January 5th, 2024

Re: Letter of Concern 3 regarding Kittitas County Conditional Use Application CU-23-00001

QUESTIONS AND CONCERNS REGARDING KITTITAS COUNTY CU-23-00001

Drawing file: CU-23-00001 3 BR Custom Cuts / CU-23-00001 3 BR Custom Cuts - Site Plan (REVISED APPLICATION) 4-4-23.pdf

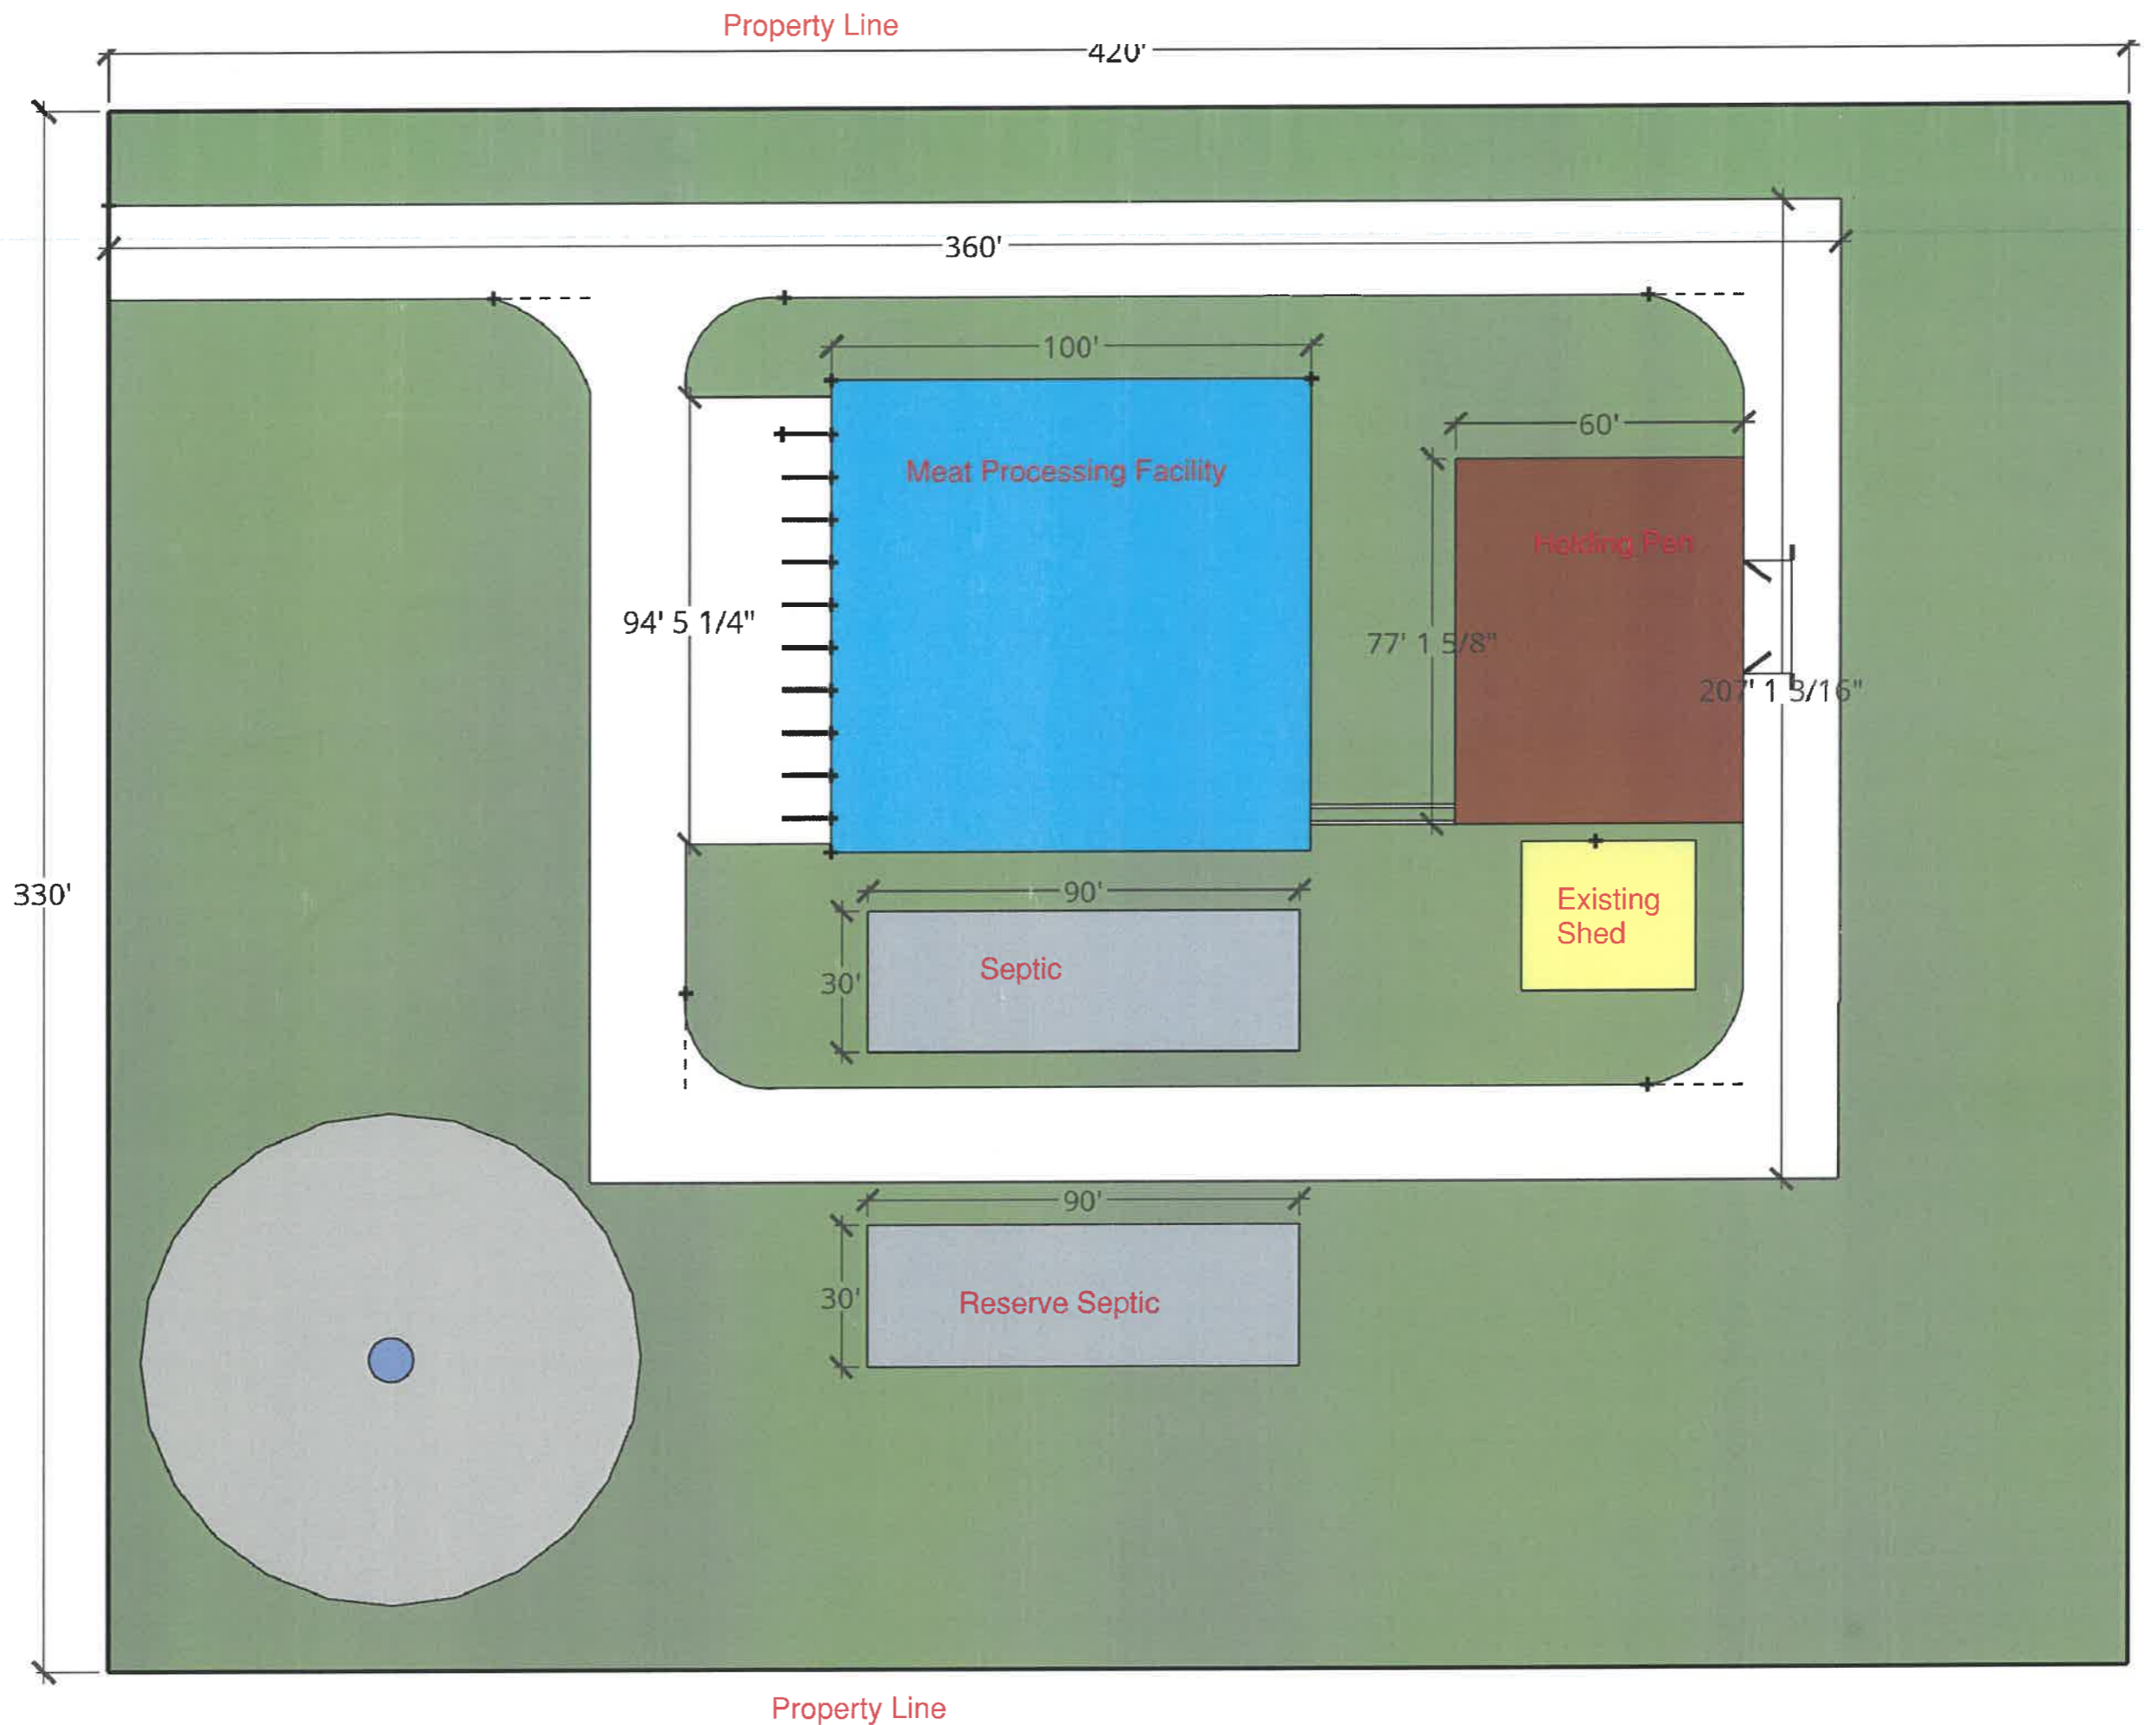
Wilson Creek is a 50mph zone adjacent to this site. A modest sized stock trailer is forced to enter and block oncoming traffic to make a right angle turn as noted in the site plan included within this reapplication posing a public safety hazard.

- Is the Wilson Creek Rd frontage with the sharp right angle turn onto the highway (as denoted on the site plan) sufficient for livestock trucks and the offal removal trucks to access Wilson Creek Rd—with its minimal shoulders, its 50mph speed zone—without encroaching into oncoming traffic and/or impeding the flow of traffic posing a potential threat to public safety?
